HANNAH RIDGE AT FEATHERGRASS FILING NO. 5

CONSTRUCTION PLANS

OCTOBER 2018

HANNAH RIDGE AT FEATHERGRASS FILING NO. 5, 6 & 7 OVERLOT GRADING AND EROSION CONTROL PLAN			
DESIGNED BY	KRC	SCALE	DATE 10/12/18
DRAWN BY	KC	(H) 1" = 50'	SHEET 3 OF 11
CHECKED BY		(V) 1" = NA	JOB NO. 1116.05

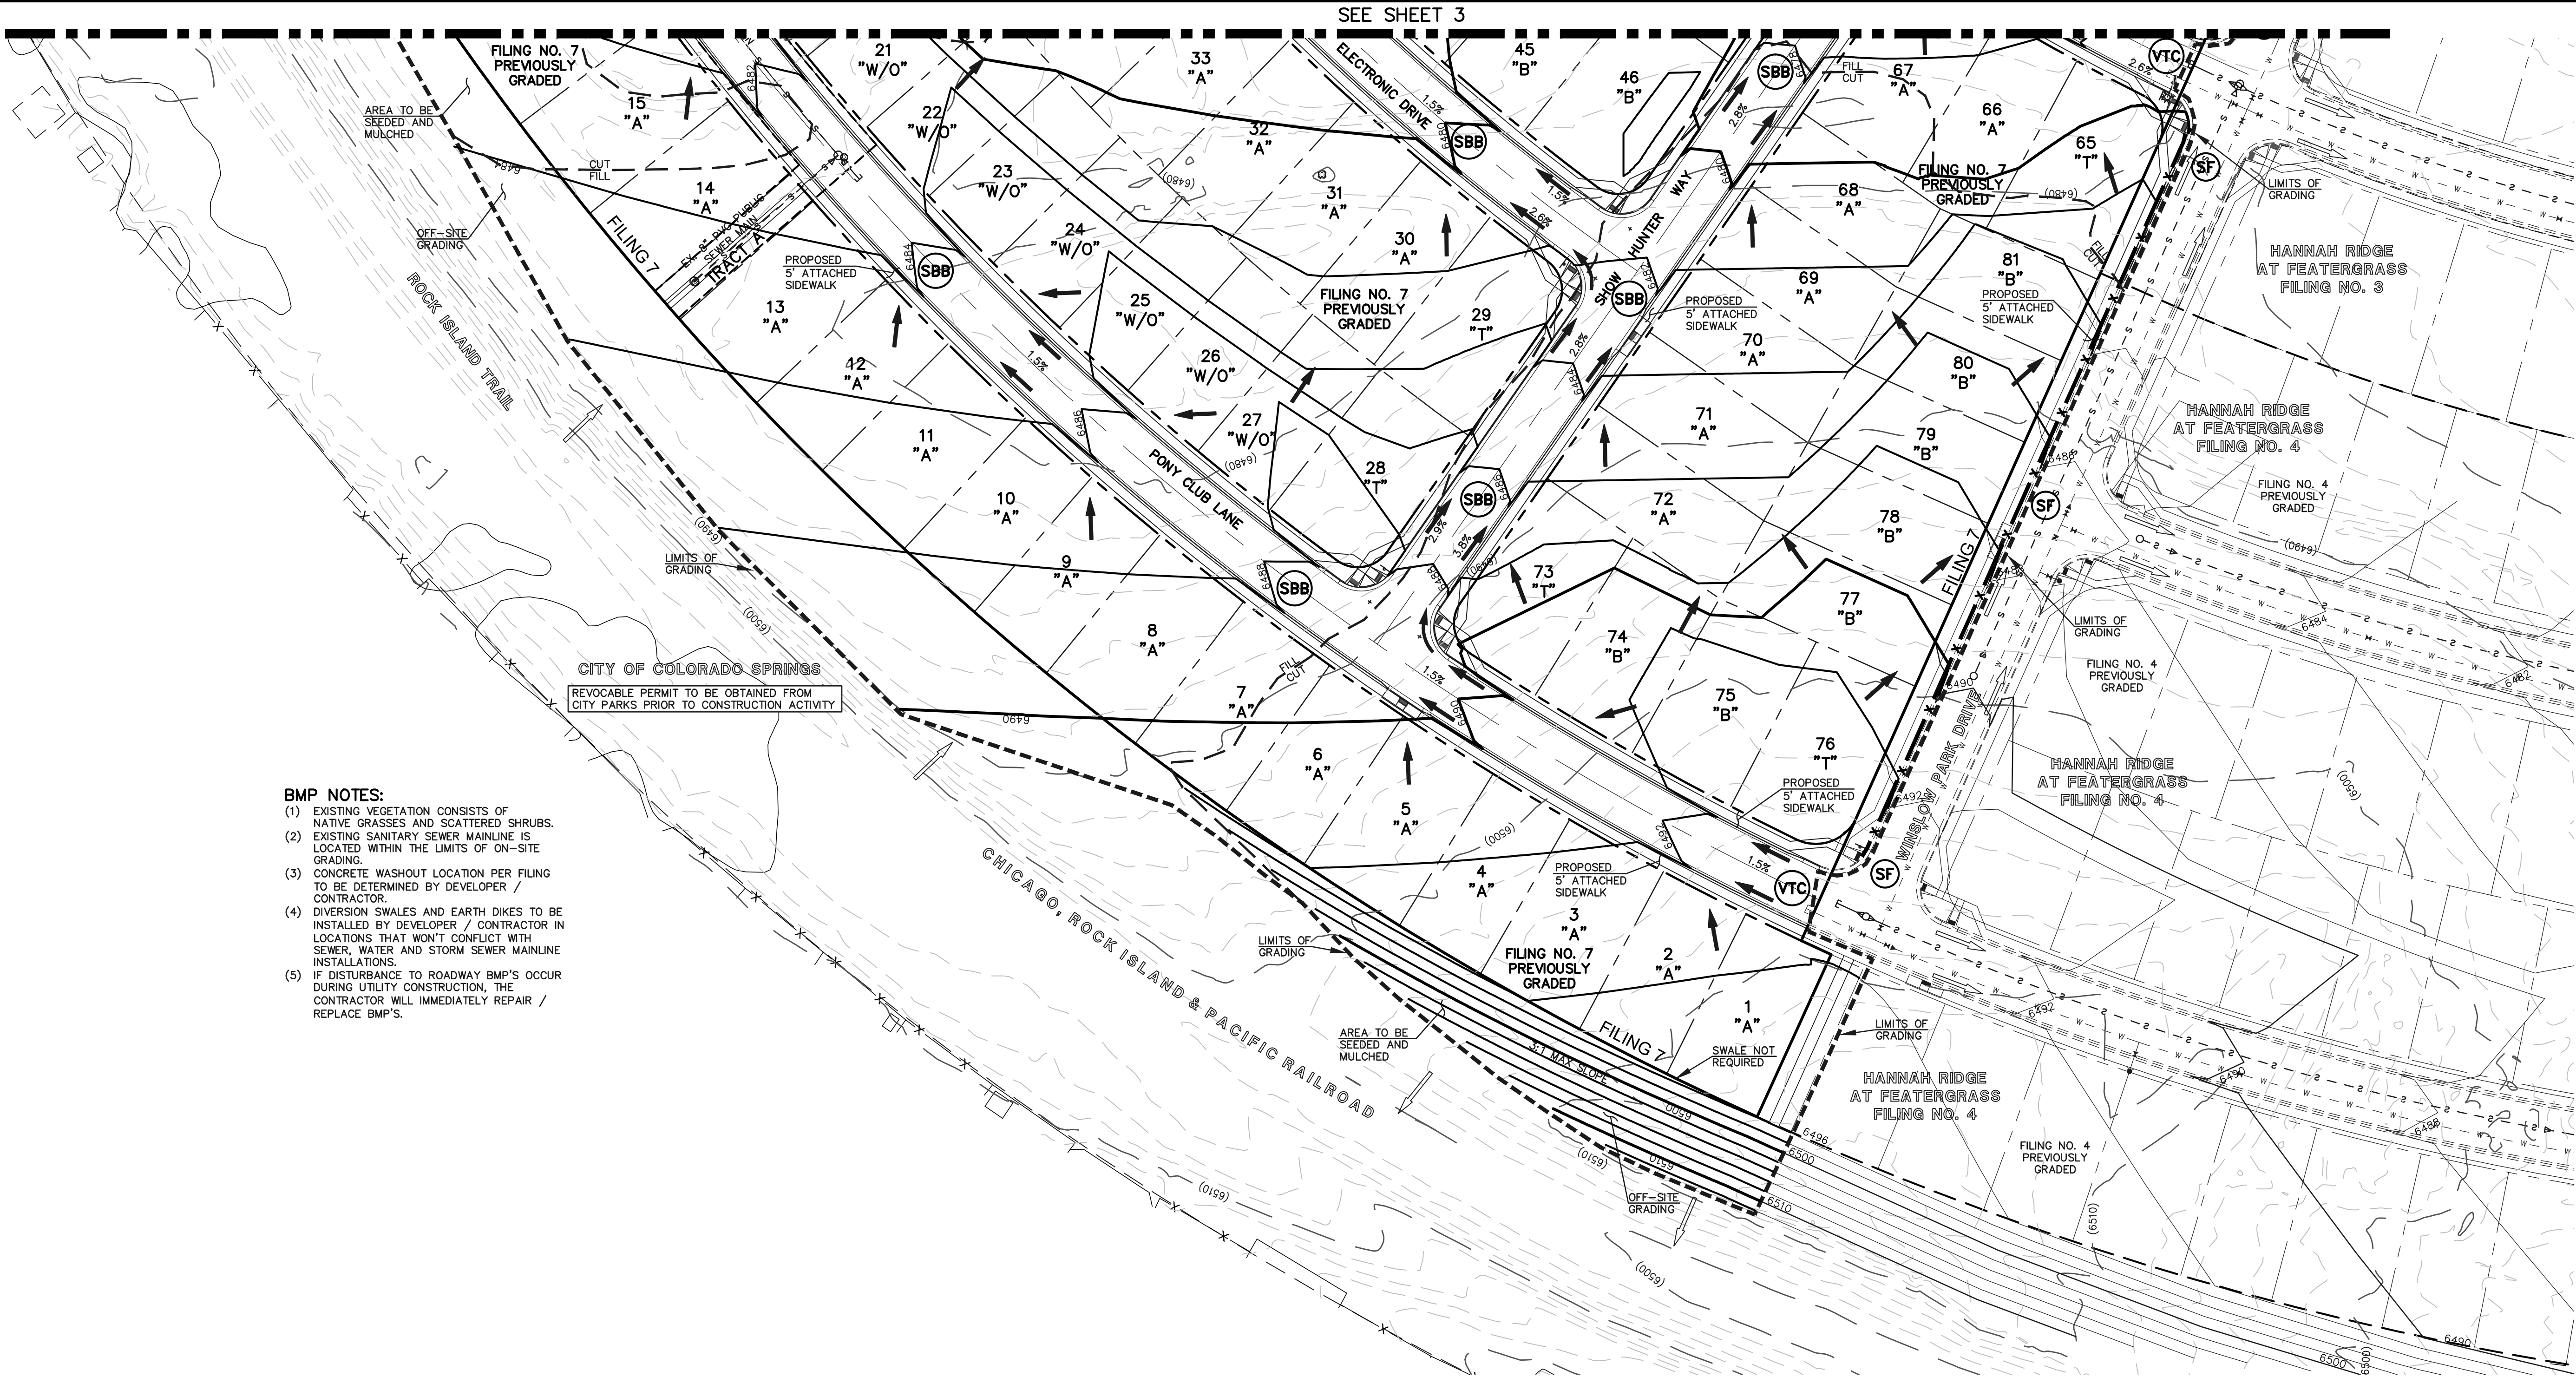
There is generally an insufficient amount of sediment control shown on this plan. For example:
 There is only one TSB where they are recommended in the criteria to be placed for roughly one acre areas.
 There is no concrete wash out shown.
 There is no provisions for, or ditch checks provided to stop erosion where the curb and gutter will be constructed.
 There are several areas (back yards, etc) where silt fence should be shown.

EQUINE COURT
 (PUBLIC 50' ROW) DESIGN SPEED - 25mph RESIDENTIAL

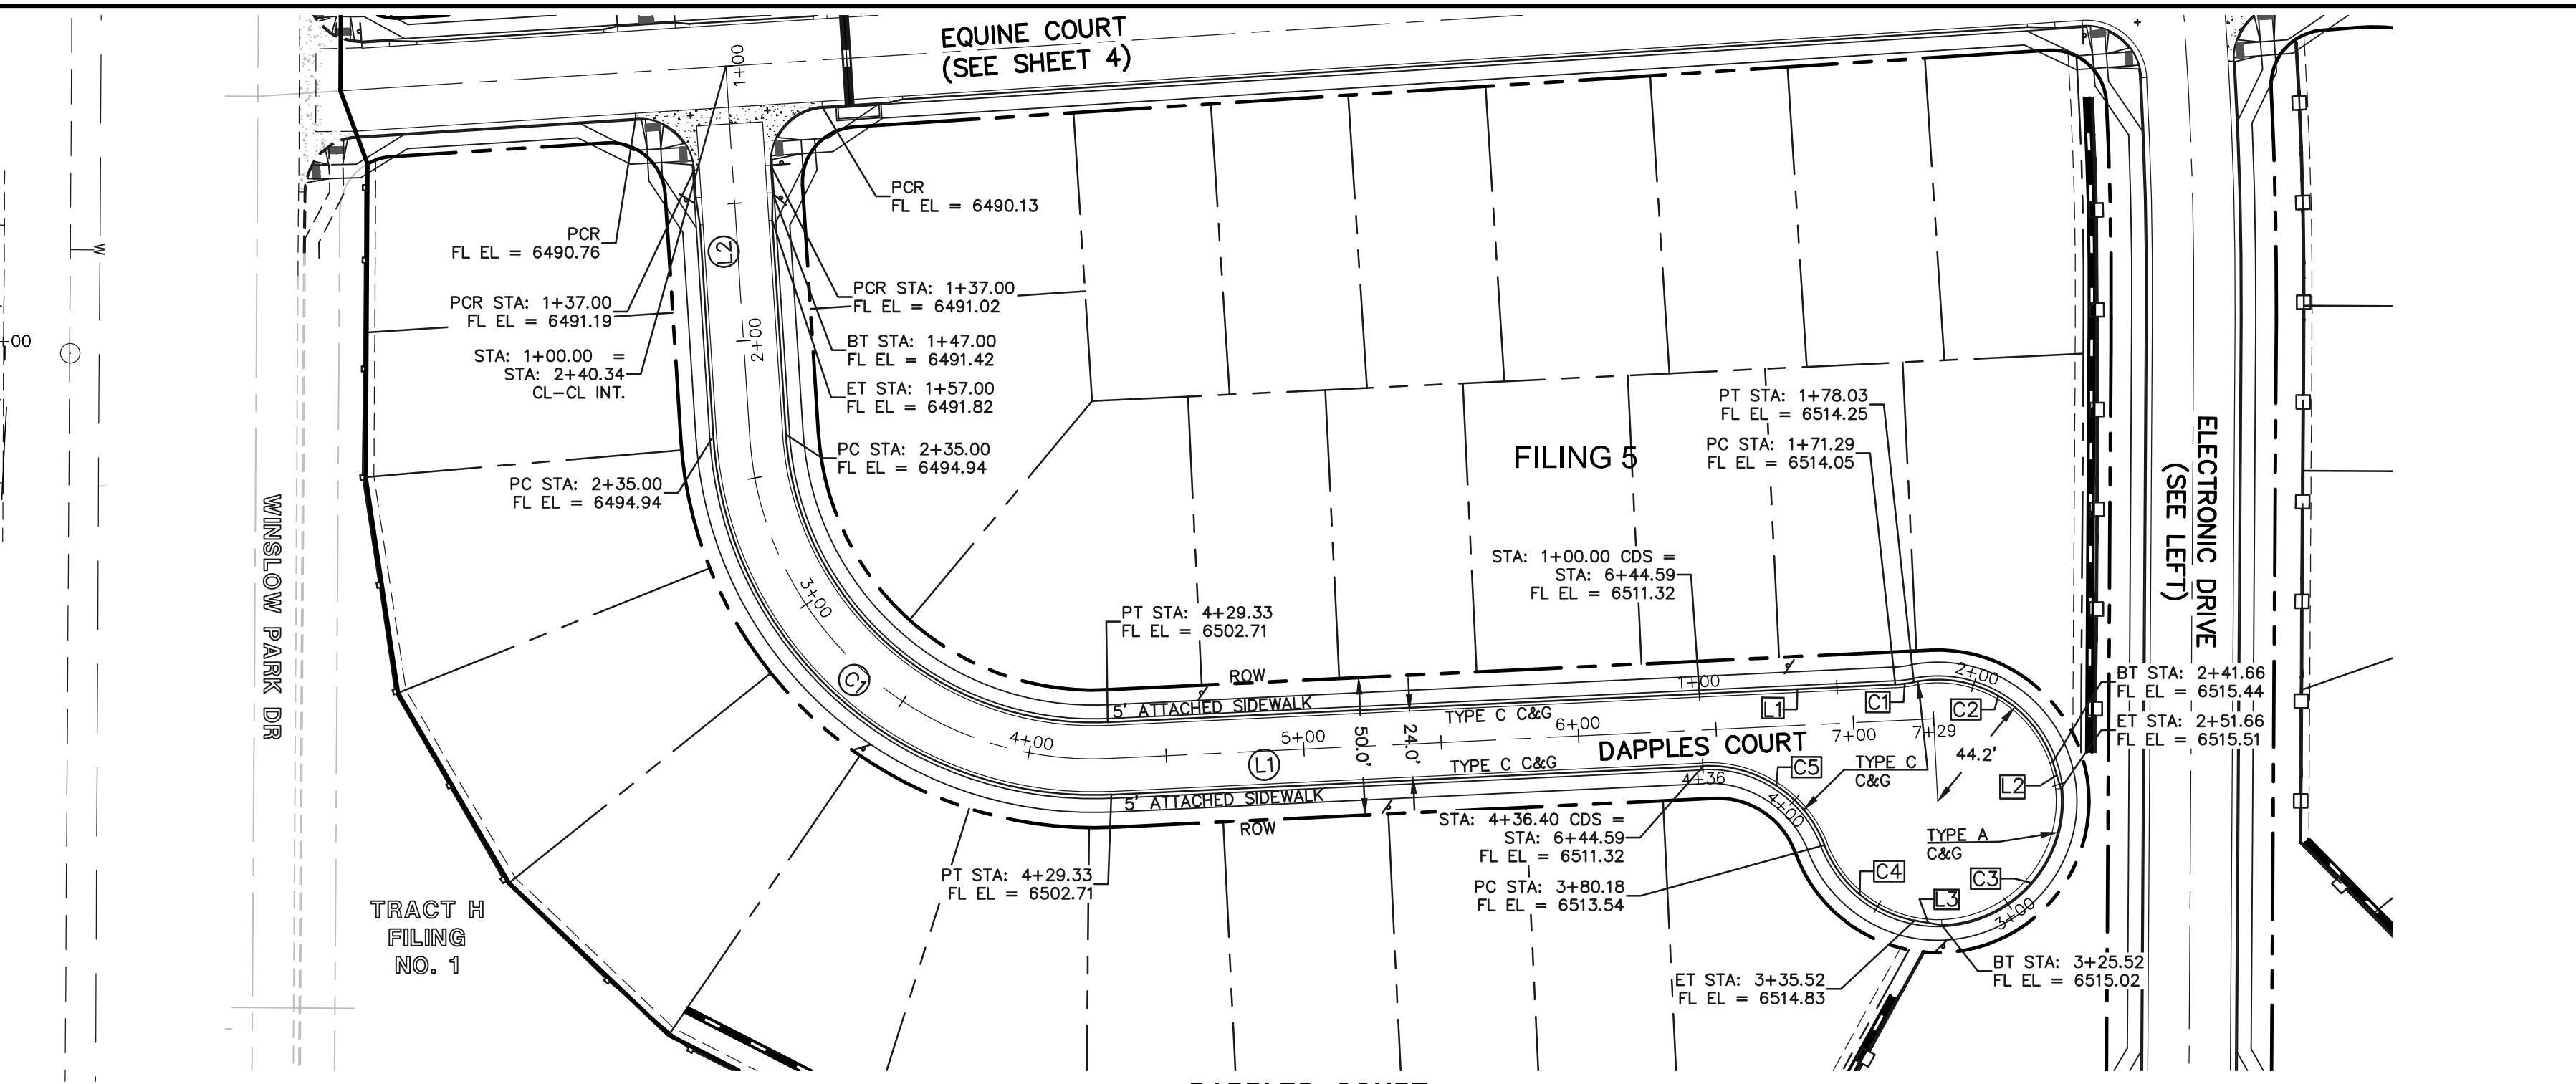
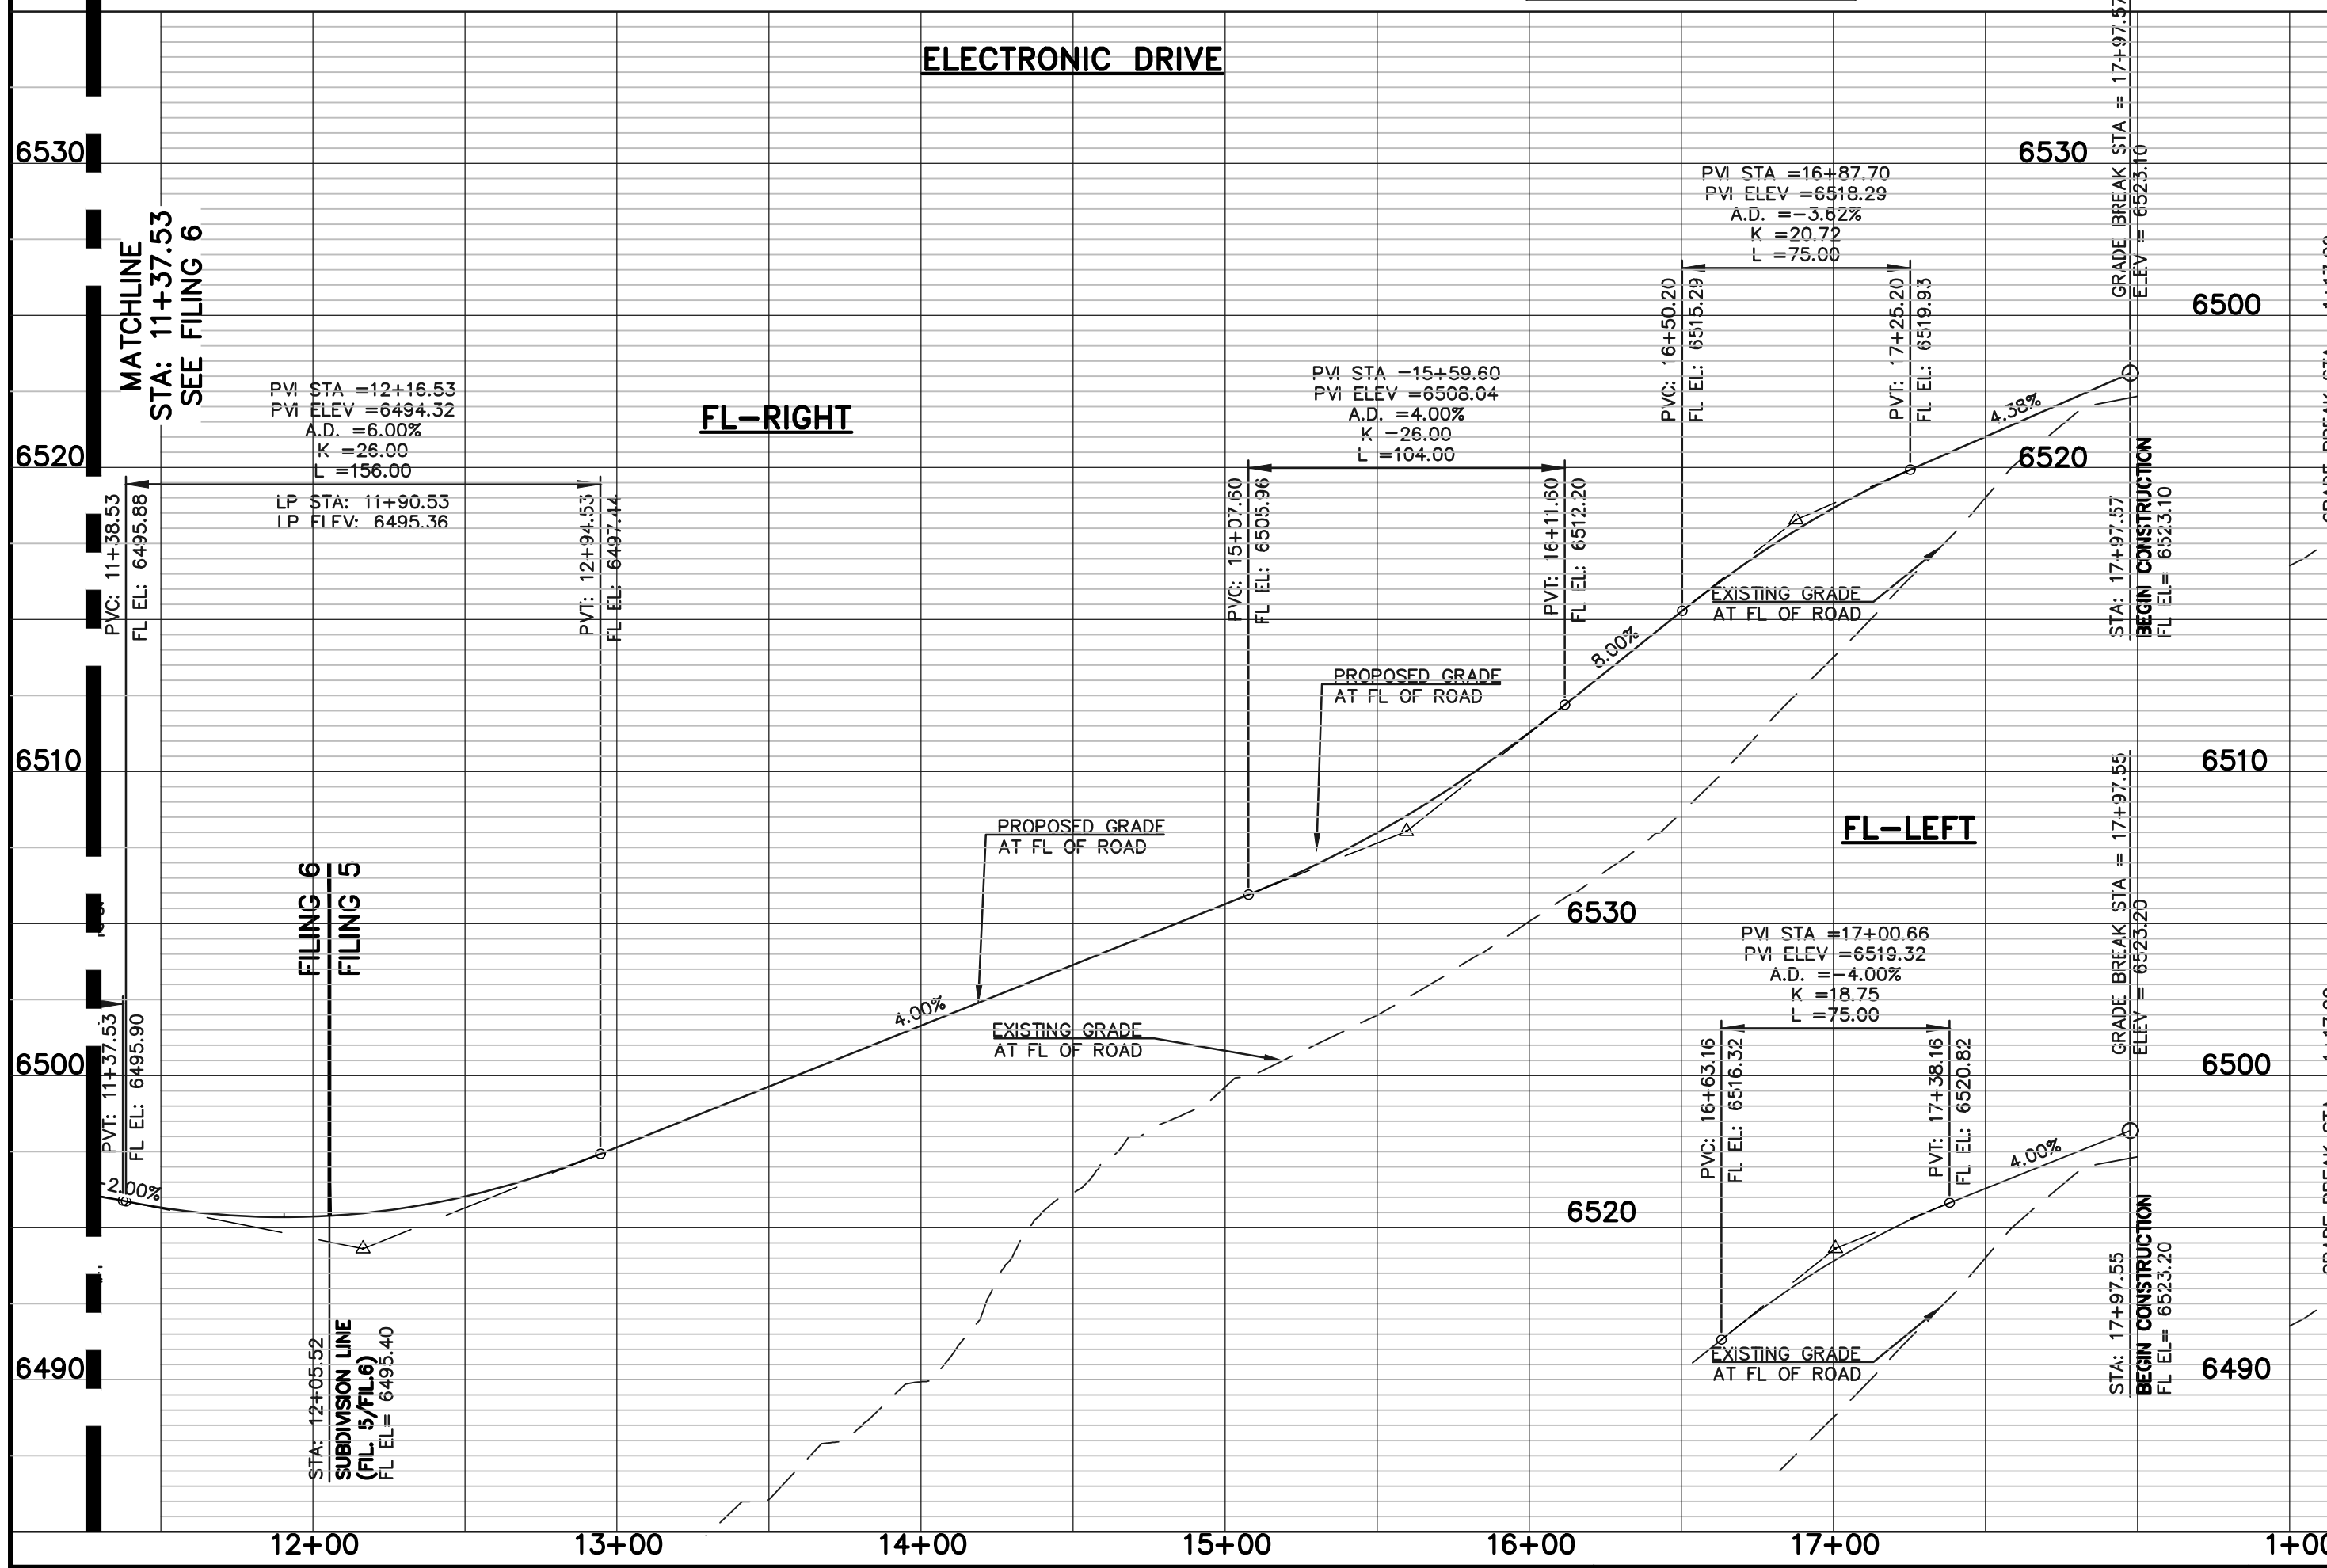
Provide Signing and Striping Plans for all three filings.
